**RE: Glendale Subdivision  
8321 Glendale Ave. NE  
Grading and Drainage Plan  
Engineer's Stamp Date: 08/03/20  
Hydrology File: B20D068**

Based upon the information provided in your submittal received 08/04/2020, the Grading and Drainage Plan **is not** approved for action by the DRB for Preliminary Plat. The following comments need to be addressed for approval of the above referenced project:

**BEING A REPLAT OF LOT 31, BLOCK 3, UNIT 2, TRACT 2, NAA
GRADING & DRAINAGE PLAN**

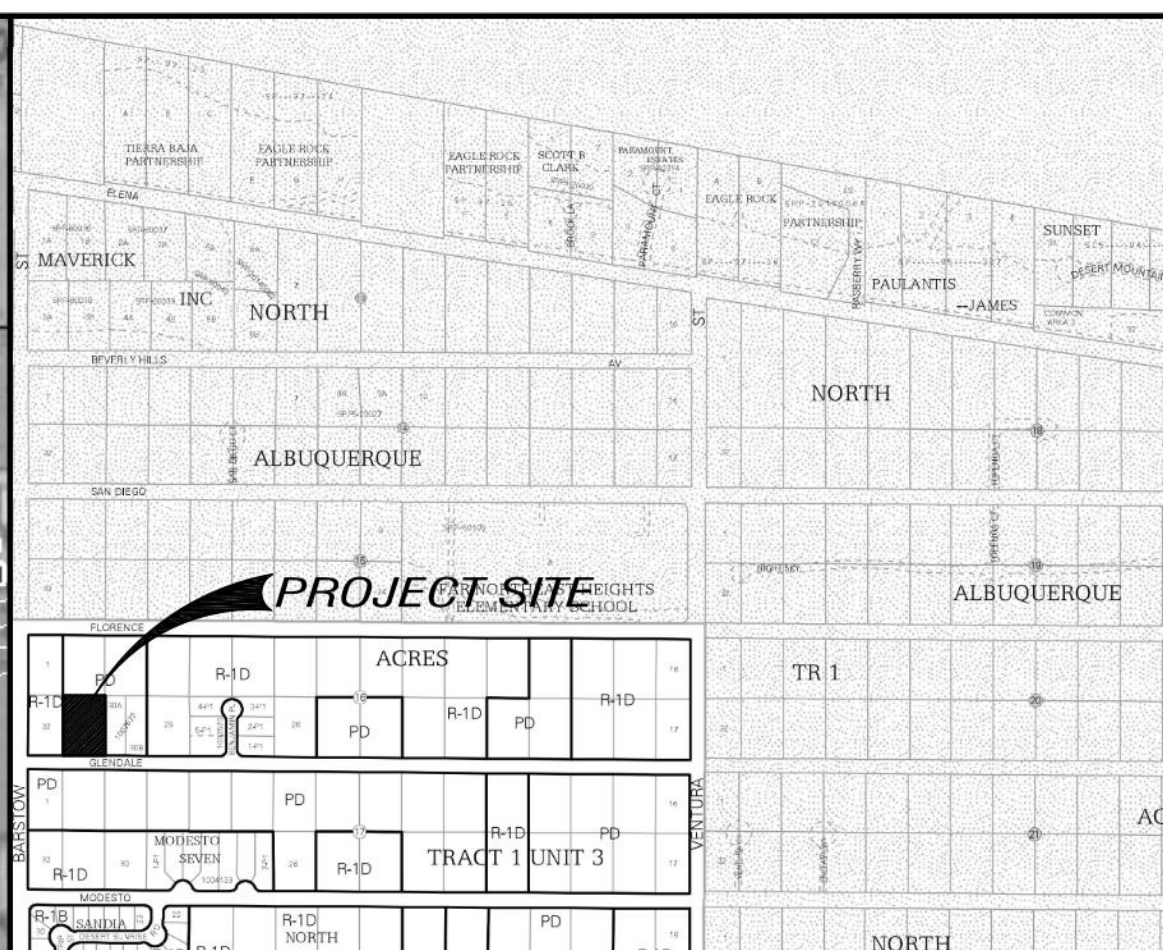
1. Per Section 1-7(B)(2)(e) of the IDO, infrastructure improvements are required. For these lots, that will include sidewalks, curb & gutter, payment and an 84" storm sewer (see below) that was called out in the NAA MDP.

2. All infrastructure improvements that are needed per the IDO must be shown and designed on the Grading & Drainage Plan.
3. Section 1. There is some question to the stability of the proposed retaining wall right next to the existing wall. In accordance with DPM Part 6-4(B), grading and wall construction near the property line may not endanger adjacent property or constrain its use. Please provide structural calculations to show that this design will a hear to the DPM.

4. For all proposed retaining walls, please provided the top of wall elevation at the beginning, middle, and end of the wall. Also state the beginning and end of the walls.
